LIST OF AMENDMENTS for submission of NMA to LU/205/16/PL
15160 – CAMMELL – LINDEN PARK

DRAWING NUMBER	15160/01 R2

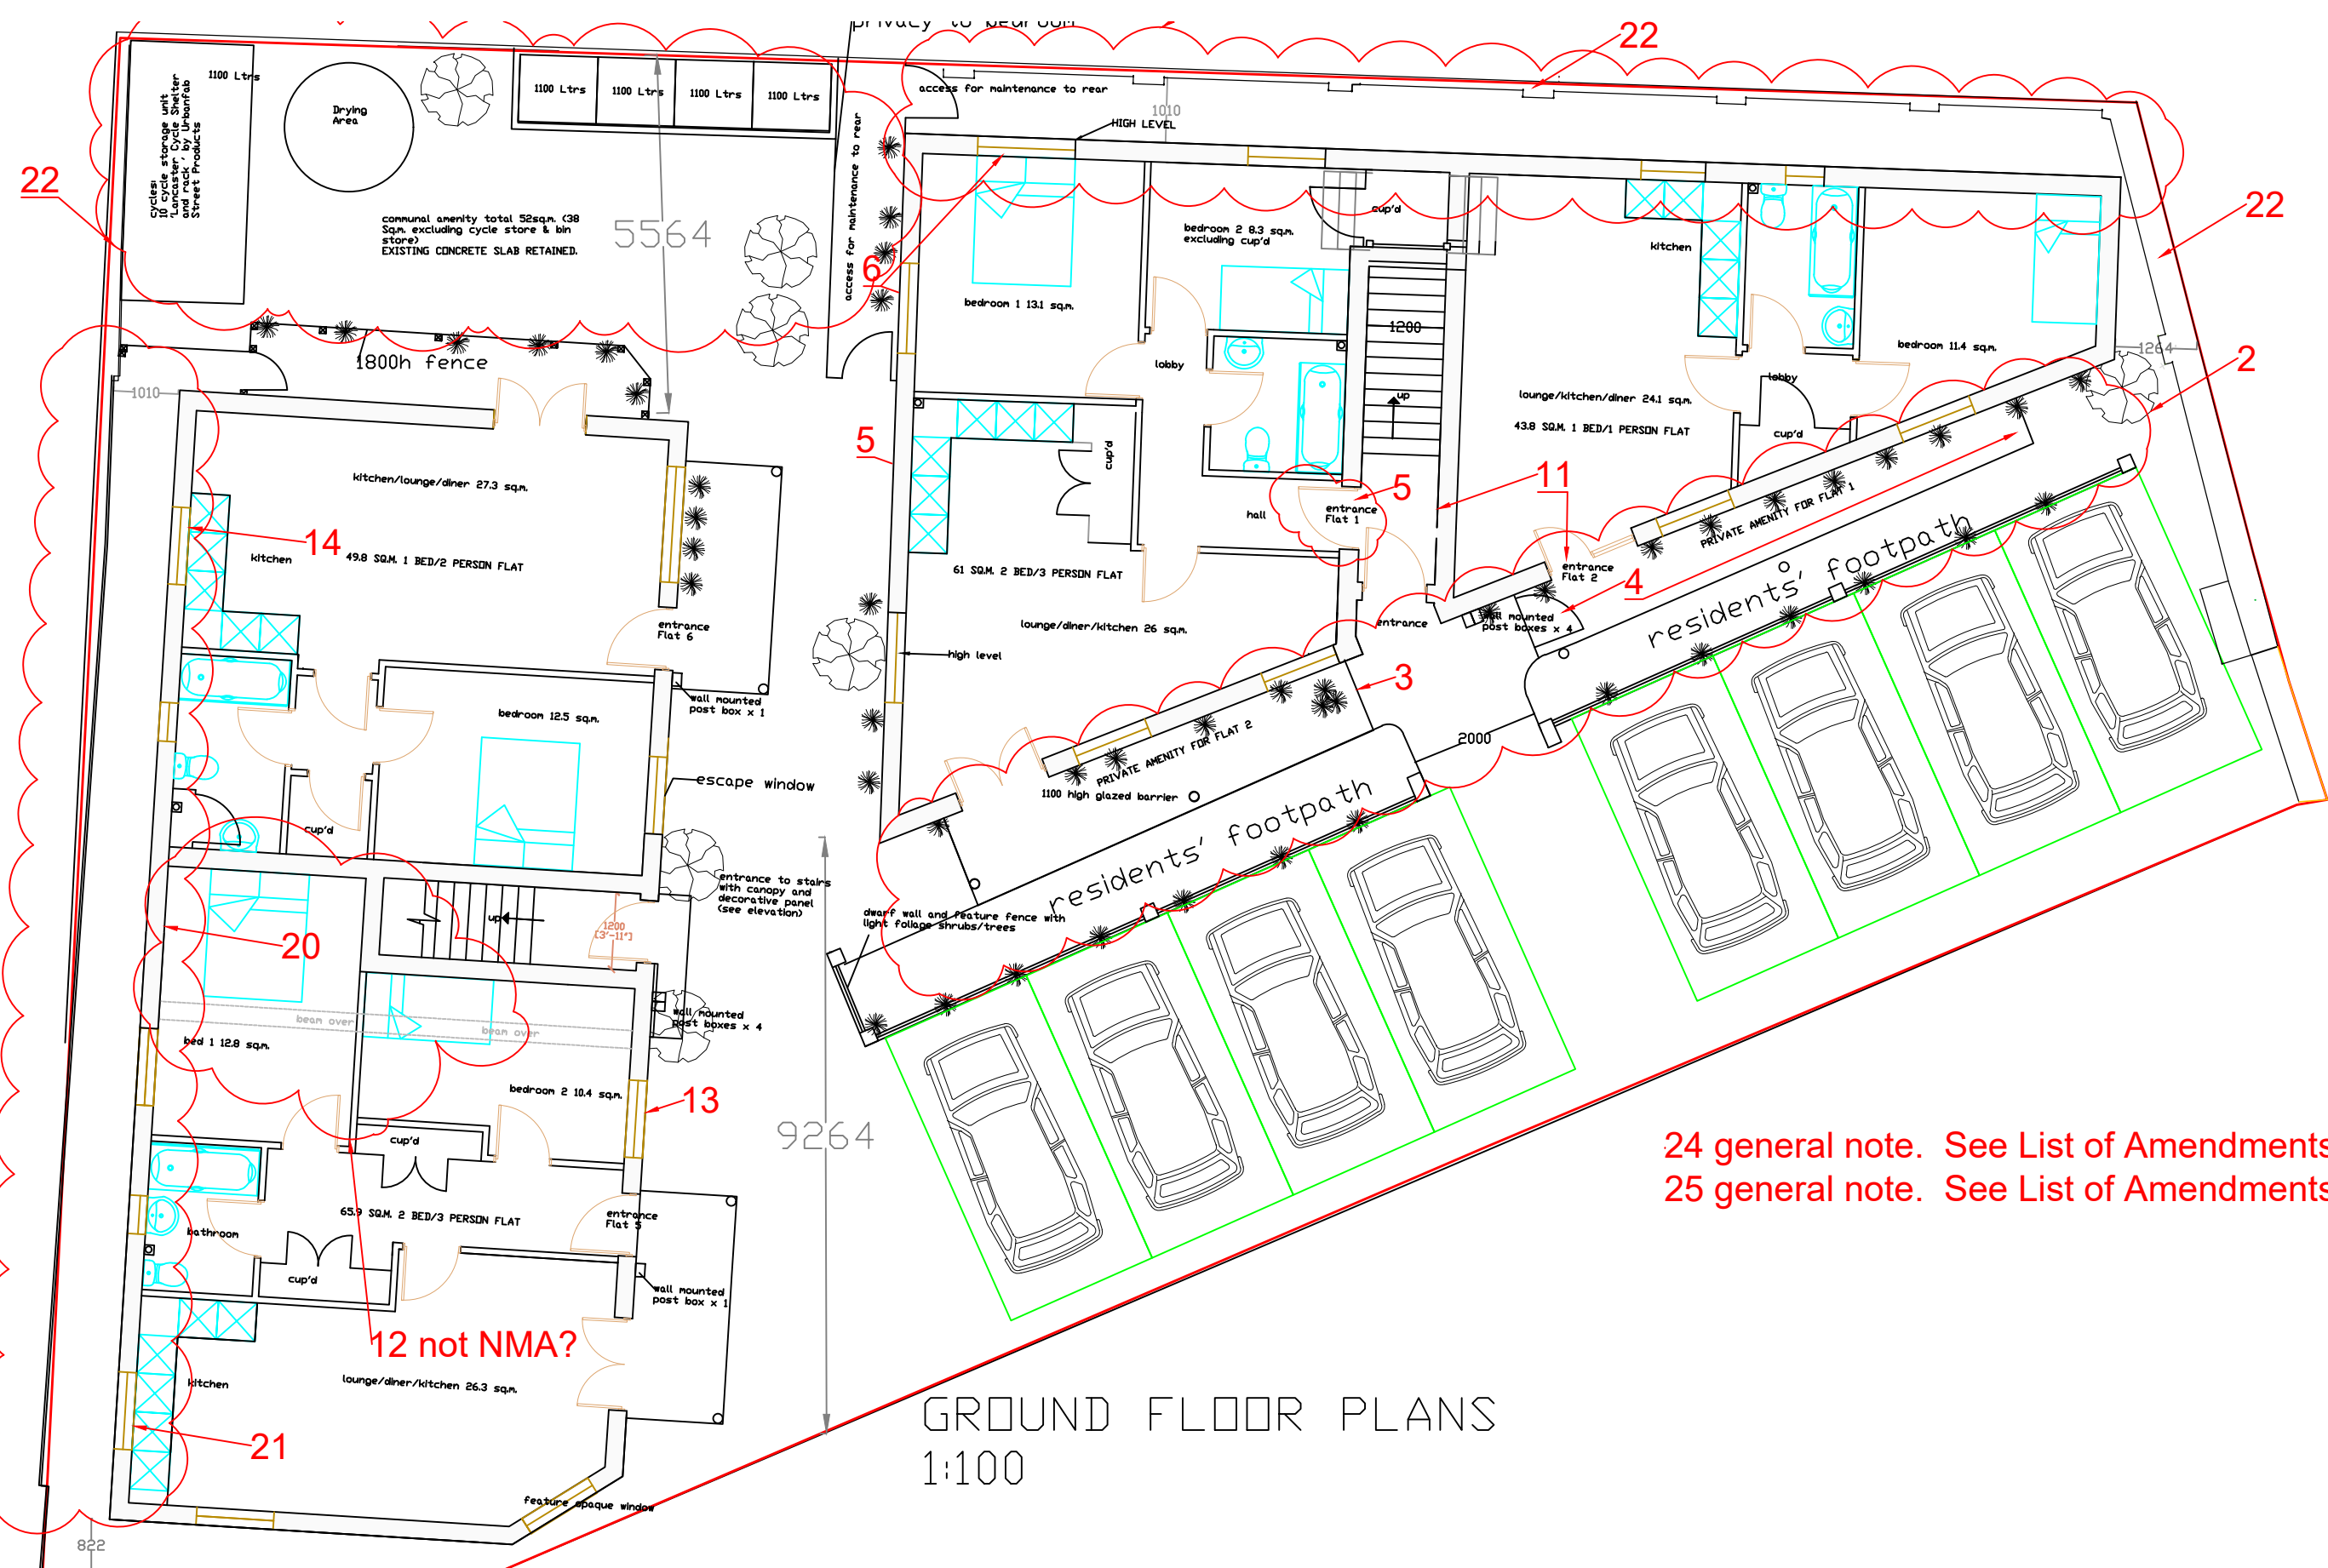
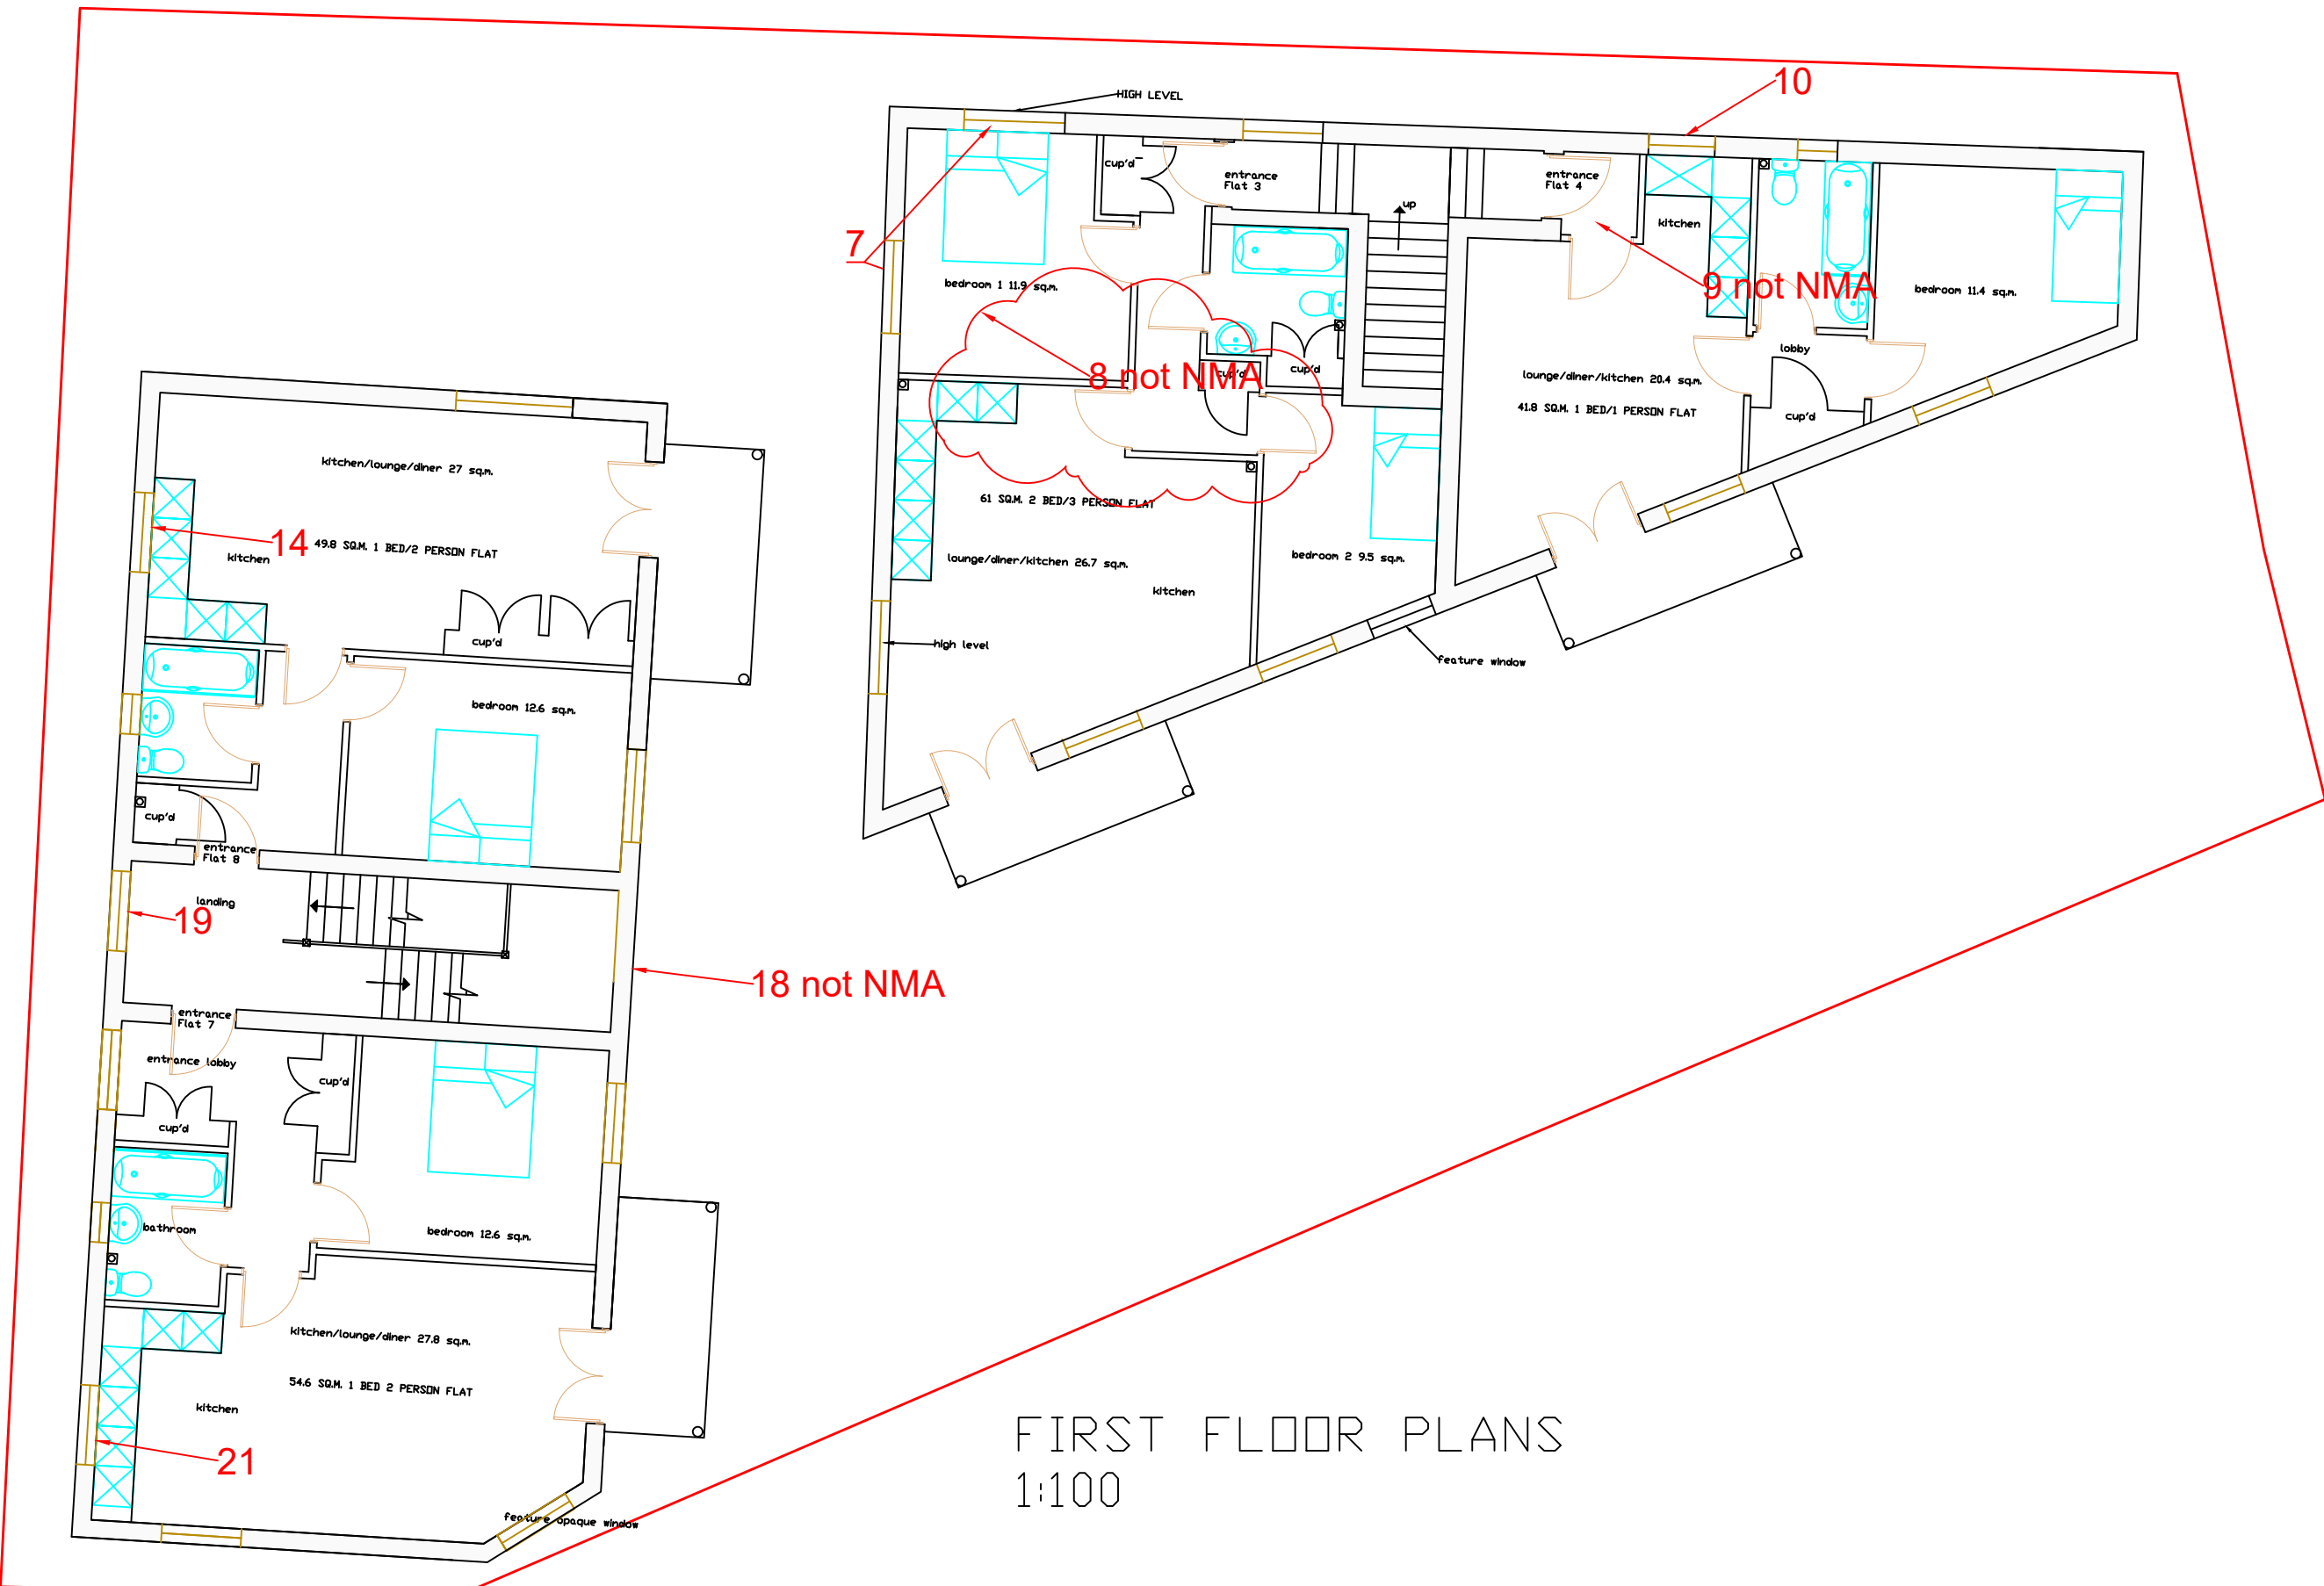
Item	Description	NMA/Info
1	Buildings set at 1010mm from boundary to allow access for scaffold and to negate the need for fire rated glazing on elevations which need to be 1M from the boundary. Buildings also swivelled slightly on site to line up: Block 1 to South Boundary Block 2 to West boundary	Yes NMA
2	Footpath move down and amenity space width reduced slightly to accommodate for moving building forward. Car parking not affected	Yes NMA
3	Flat 1 – Amenity space extended to in front of window	Yes NMA
4	Flat 2 – Amenity space extended and gate added for access	Yes NMA
5	Flat 1 – Entrance to Flat 1 relocated to inside main entrance to facilitate improvements to internal layout. Original front door in South elevation removed.	Yes NMA
6	Flat 1 - High level window now in West elevation. Normal cill window in South elevation`	Yes NMA
7	Flat 3 - High level window now in West elevation. Normal cill window in South elevation`	Yes NMA

8	Flat 3 – Internal changes to line walls up with other floors	Information Only
9	Flat 4 – Internal amends to entrance to provide lobby	Information Only
10	Flat 4 – Kitchen window smaller (800 instead of 1200) and moved over	Yes NMA
11	Flat 2 – Internal entrance blocked off. Entrance now from East elevation and double doors changed to single door with full height side light	Yes NMA
12	Flat 5 – Reconfigured to line more walls up (and bathroom)	Information Only
13	Flat 5 – Window to bedroom 2 moved 250mm	Yes NMA
14	Flats 6, 8, 10 – Window to kitchen area (far West) moved inward to East by 600mm	Yes NMA
15	Flat 9 – reconfigured.	Information Only
16	Stairs from first to second floor in Block 1 reconfigured	Information Only
17	Balconies throughout. Added vertical supports to all outward corners to support reduction in cost of build.	Yes NMA
18	Block 1 (3 storey) Stairwell. FF landing window on ½ landing deleted.	Yes NMA

19	Block 1 FF landing window to South elevation made bigger to match 2 nd floor bedroom window	Yes NMA
20	Flat 5 Bedroom 1 – Small window deleted due to new internal layout	Yes NMA

21	New windows to South elevation to Block 1, flats 5, 7, 9. New windows positioned in kitchen.	Yes NMA
22	Retained walls now shown on Site Plan to North boundary. Originally the walls were to be removed and replaced with fencing. It is now proposed to retain the flint wall to this boundary as well as part of the building wall which is attached to it. It is felt this adds to the security of the site.	Information Only
23	Communal Amenity Space to put bin store more accessible to residents and collection operatives. (perhaps residents more likely to use the bin store correctly if more convenient. Also existing concrete base retained instead of planting grass which may be difficult to maintain in this area.	Yes NMA
24	General Note: Bathrooms sized, where possible, to length of bath, to support reduction in cost of build, Walls moved and reconfiguration to consolidate walls under each other in plan, wherever possible.	Information Only
